CITY OF ALBUQUERQUE
MUNICIPAL DEVELOPMENT DEPARTMENT
ENGINEERING DIVISION/DESIGN HYDROLOGY SECTION

CONFERENCE RECAP

DRAINAGE FILE/ZONE ATLAS PAGE NO.: H-22 DATE: 1-28-86
PLANNING DIVISION NOS: EPC: _____ DRB: _____
SUBJECT: Lots 152, 354 Block 6 Enchanted
STREET ADDRESS (IF KNOWN): M. Wanda Jaggars & Office more
SUBDIVISION NAME: _____

RE: DRAINAGE PLAN FOR MENAUL JAZZERCISE
RECEIVED JANUARY 31, 1986 (H-22/D55)

# GRADING AND DRAINAGE PLAN MENAU JAZZERCISE

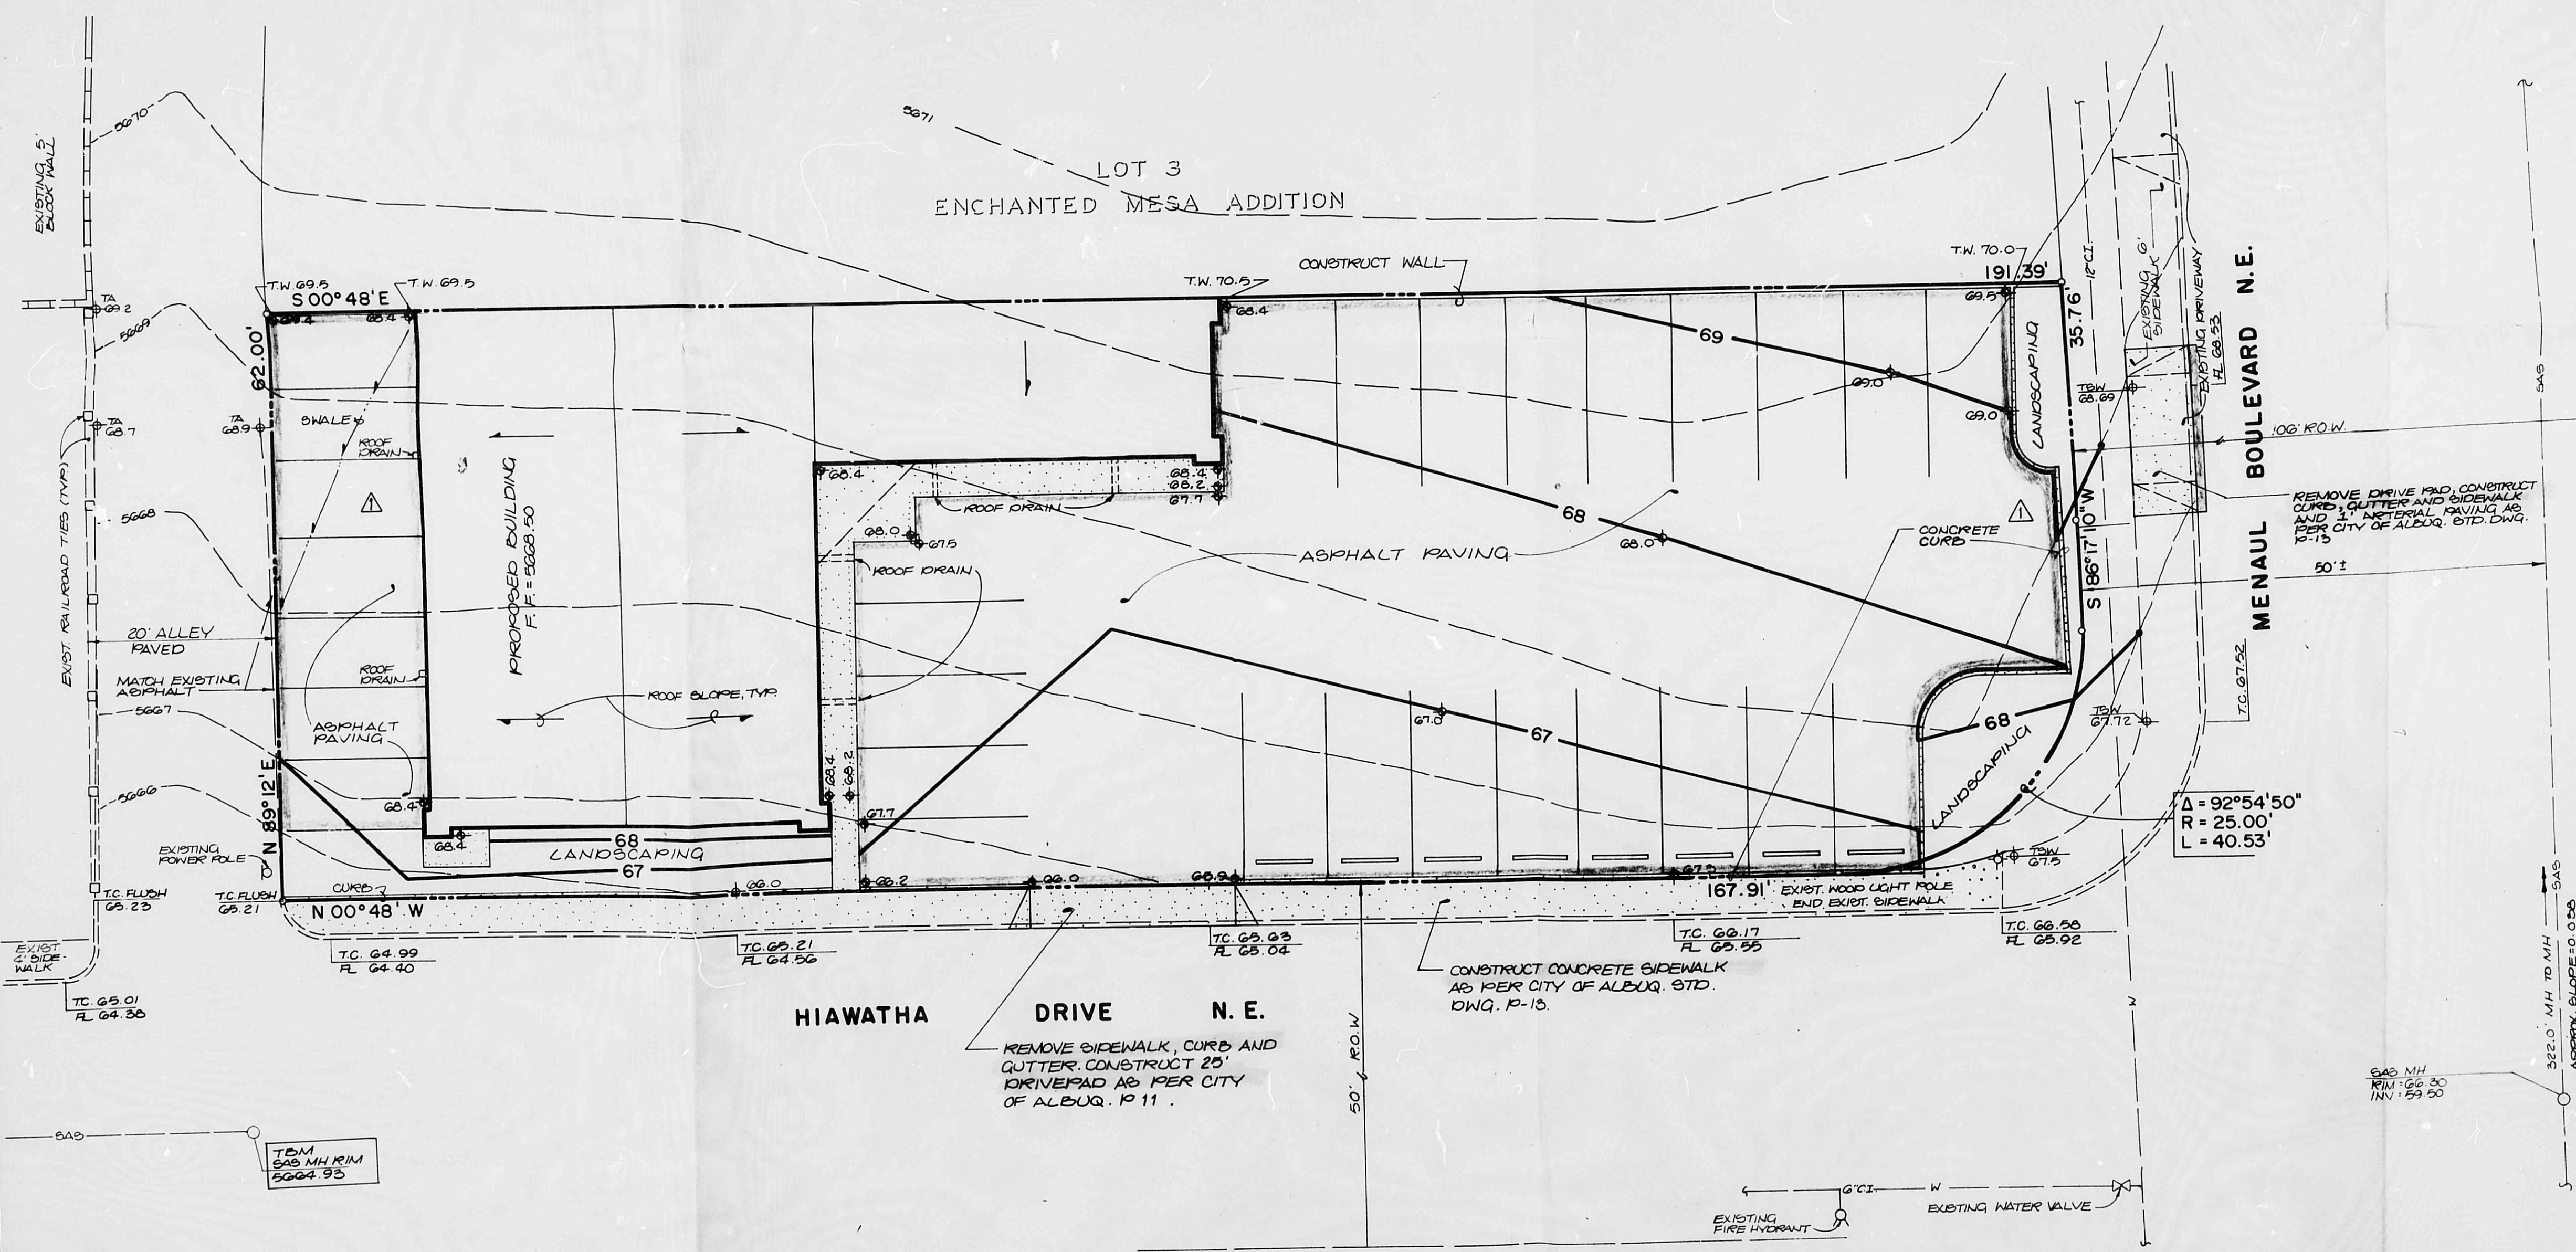
- ① Drainage plan per DPM
- ② Free discharge appears appropriate. Engineer must address
 - ① infill site
 - ② minimum impact on downstream
 - ③ improvements made on downstream flooding
 - ④ no other ponding areas in watershed
- ③ Remove lot lines for flow across lot lines
- ④ Total length of alley is per spec. Alley will not be used to discharge site

Please be advised that the building permit will not be released until an approved filed copy of the replat is submitted to our office indicating lot line removal.
